# Statement of Common Ground with Natural England (draft)

August 2025

- 1.1.1 This Statement of Common Ground (SoCG) has been prepared to support the Examination of the Development Consent Order (DCO) application (the 'DCO Application') for Peartree Hill Solar Farm (the 'Proposed Development').

Figure 7.1: Designated Sites and Ecological Mitigation and Enhancement Areas

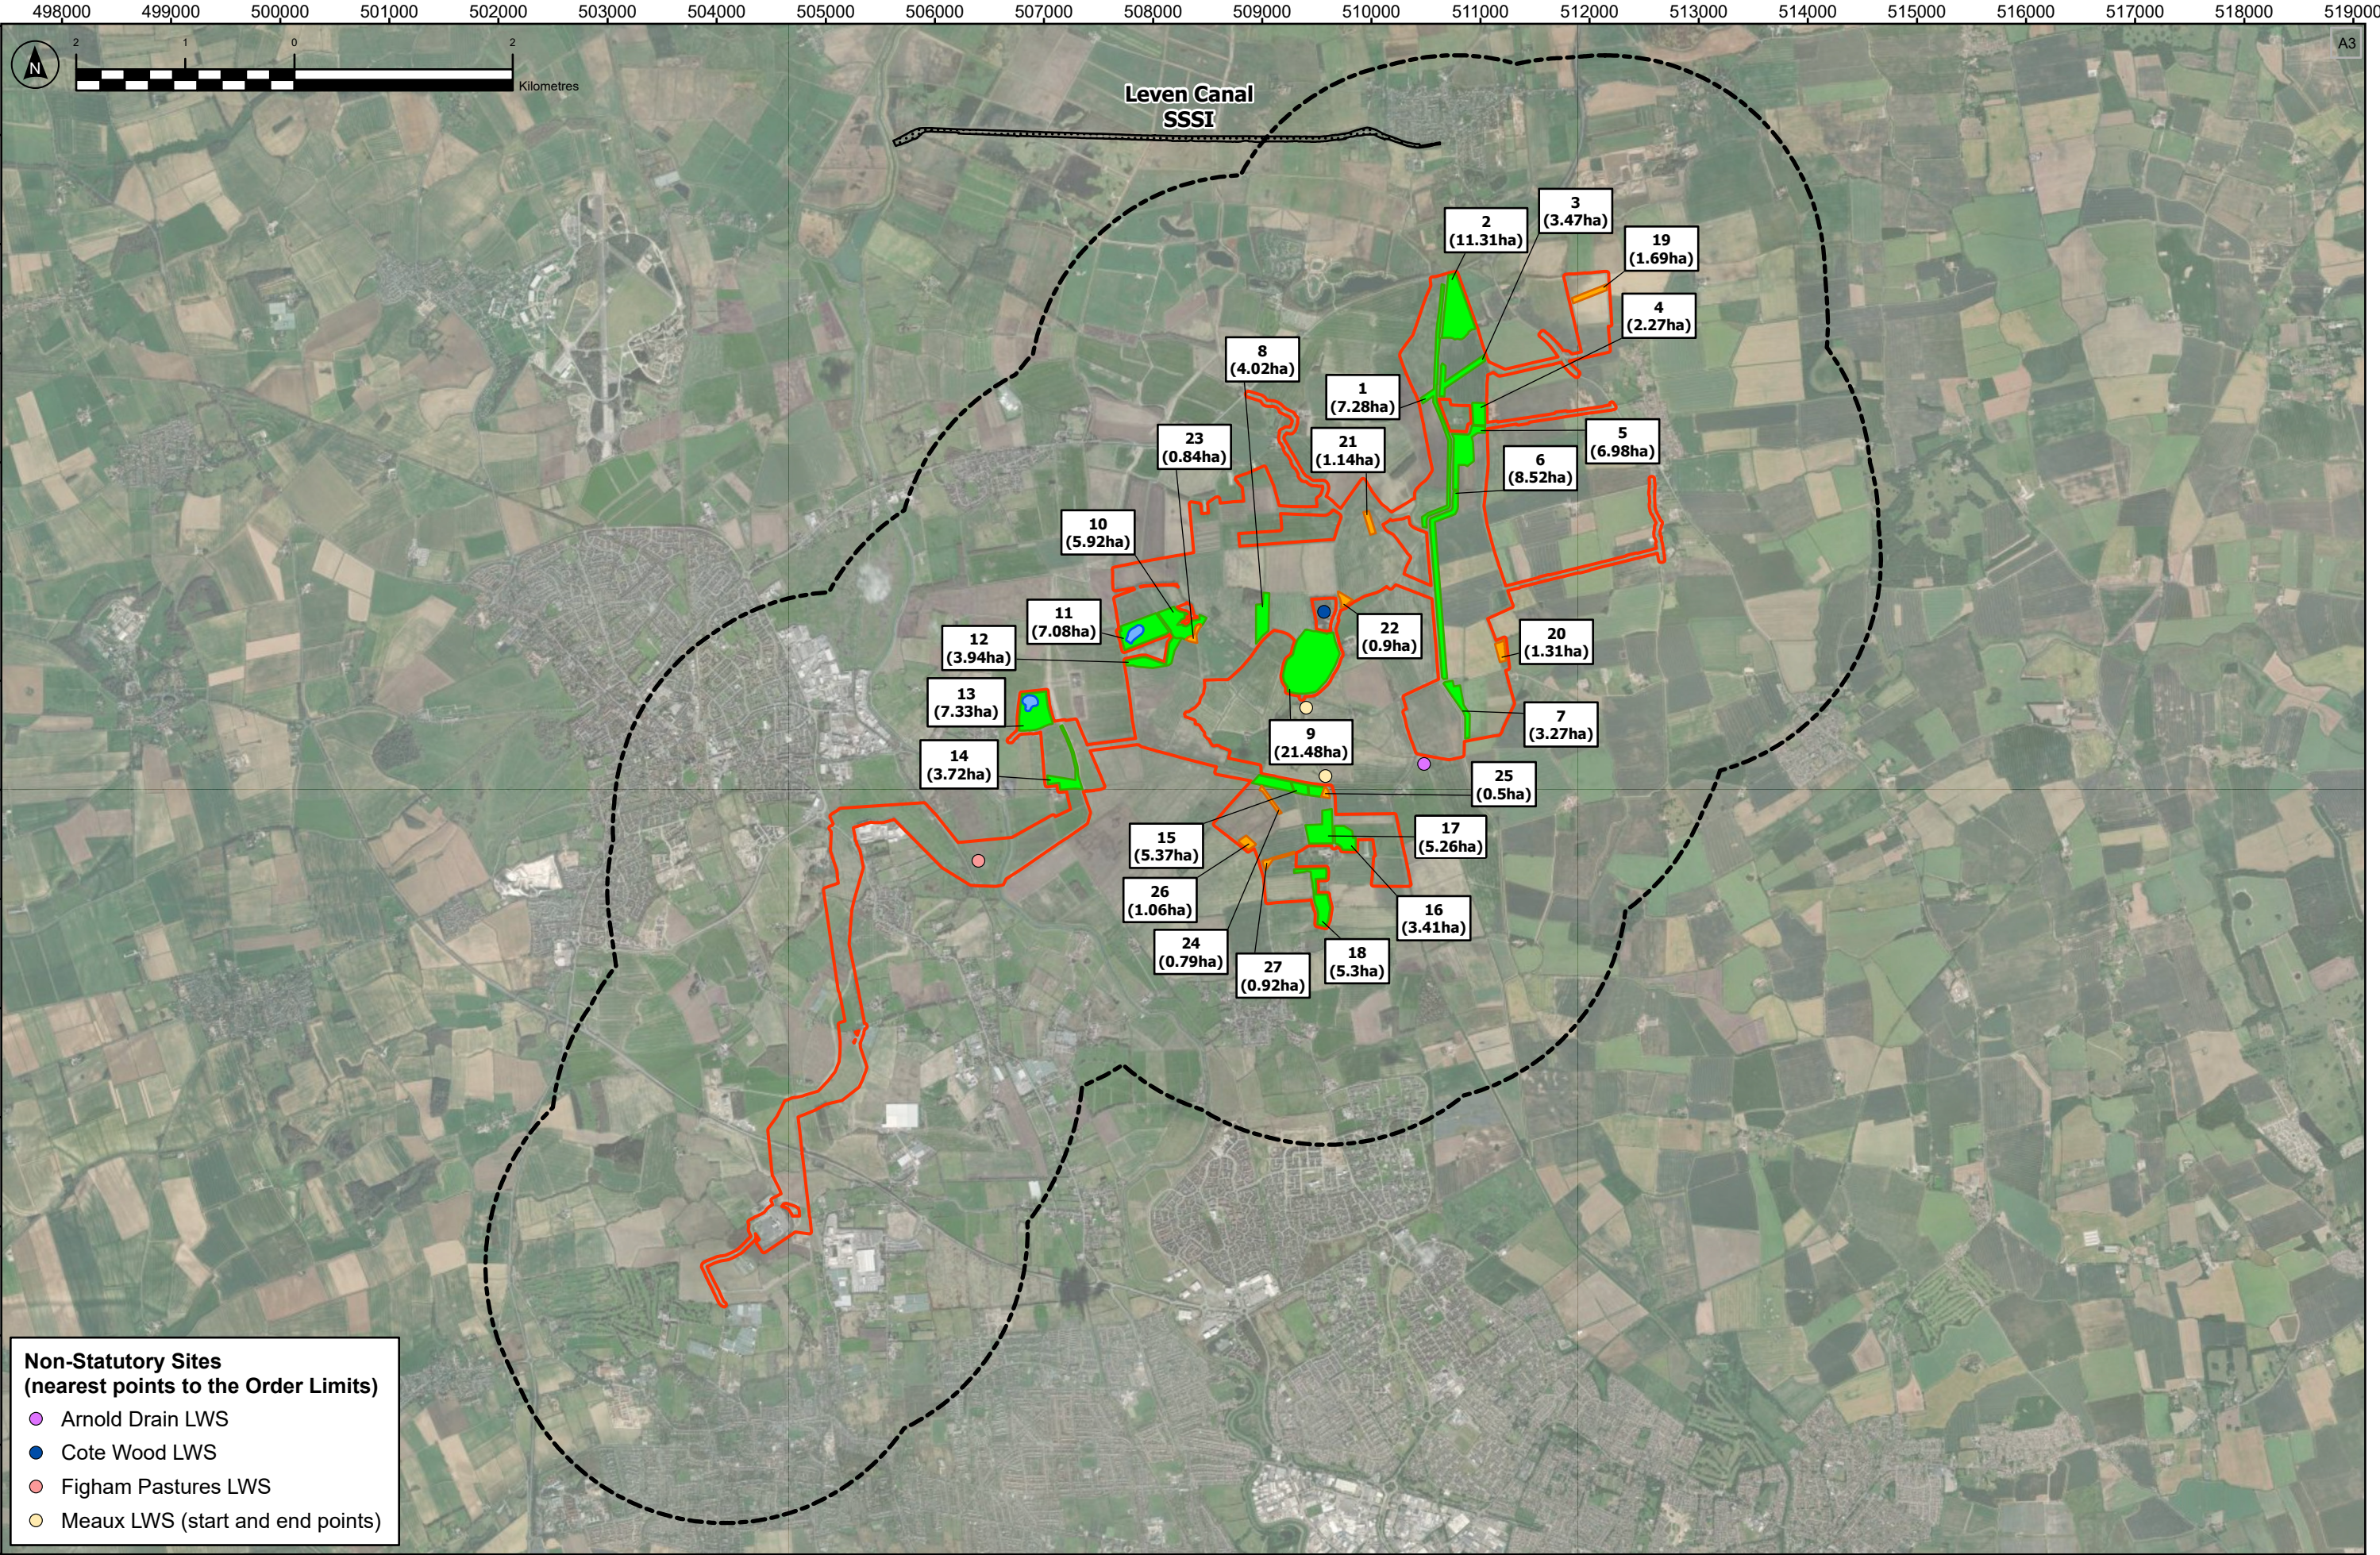
Ref	Topic	Natural England's Position	Applicant's Position	Status
		Natural England welcomes the incorporation of the new data in the updated HRA at Deadline 1. Natural England will review the information and provide comments at Deadline 2.		
International designated sites – mitigation areas				
NE03	Core mitigation areas and the implementation of a buffer  <i>Biodiversity</i>	In their relevant representation <b>[RR-012]</b> (NE1a), Natural England advises that all core mitigation areas should be surrounded by a buffer of 150m, within which the land use is secured for a purpose which will not affect the integrity of the mitigation area. However, Natural England agreed in principle at a meeting on 19 June 2025 that the presence of screening (e.g. hedgerows) between proposed mitigation areas and areas of solar PV modules would negate the need for a 150m buffer from the solar PV modules from a visual impact perspective, assuming hedgerows are high enough to screen panels and other works. Natural England requested that if a 150m buffer is not included within the proposals, further assessment of the suitability of areas closer to the panels (e.g. some species rely on open vistas to forage), and the amount of 'core habitat' available, should be provided. The 'core	<p>The 'bird days' calculation to gauge the quantum of mitigation for bird species associated with International Designated Sites has been updated to take account of data from the <b>Grid Connection Cable Route Bird Survey Report [EN010157/APP/8.4]</b>, which is submitted at Deadline 1. The <b>Outline LEMP [EN010157/APP/7.5 Revision 3]</b> has been updated to incorporate the amended 'bird days' calculations as well as to provide further assessment of the suitability and the potential carrying capacity of each mitigation area to deliver mitigation for the intended species.</p> <p>The Applicant will continue to engage with Natural England on this topic.</p> <p>The updated <b>Outline LEMP [EN010157/APP/7.5 Revision 3]</b> is submitted at Deadline 1.</p>	Under discussion

Ref	Topic	Natural England's Position	Applicant's Position	Status
		<p>habitat' should be of sufficient size and ecological suitability to deliver the required mitigation for the birds displaced by the development.</p> <p><u>Update 8 August 2025:</u>  Natural England welcomes that further information will be provided in the Outline LEMP at Deadline 1. Natural England advises that justification should also be included in the HRA, where relevant to the conclusions of the assessment. Natural England will review the information and provide comments at Deadline 2.</p>		
NE04	<p>Permissive paths and the proposed mitigation areas</p> <p><i>Biodiversity</i></p>	<p>In their relevant representation <b>[RR-012]</b> (NE1b), Natural England noted that Figure 3.4 Indicative Environmental Masterplan [APP-058] detailed proposed permissive walking routes around mitigation areas 9 and 11 and advised that the impact of these paths on the functionality of the proposed mitigation areas should be assessed in the HRA. Natural England also requested clarification on whether the proposed footpaths will be separated from the mitigation areas by fencing to prevent dogs from entering the mitigation areas.</p>	<p>The Applicant is investigating ways to address this issue, such as the re-routing of the proposed permissive paths around mitigation areas 9 and 11, the use of signage in appropriate locations instructing dog walkers to keep their dogs on a lead and/ or additional fencing. The Applicant will continue to engage with Natural England on this topic.</p> <p>The <b>Outline LEMP [EN010157/APP/7.5 Revision 3]</b> and <b>ES Volume 3, Figure 3.4: Indicative Environmental Masterplan [APP-058]</b> will be updated to reflect any changes as</p>	Under discussion
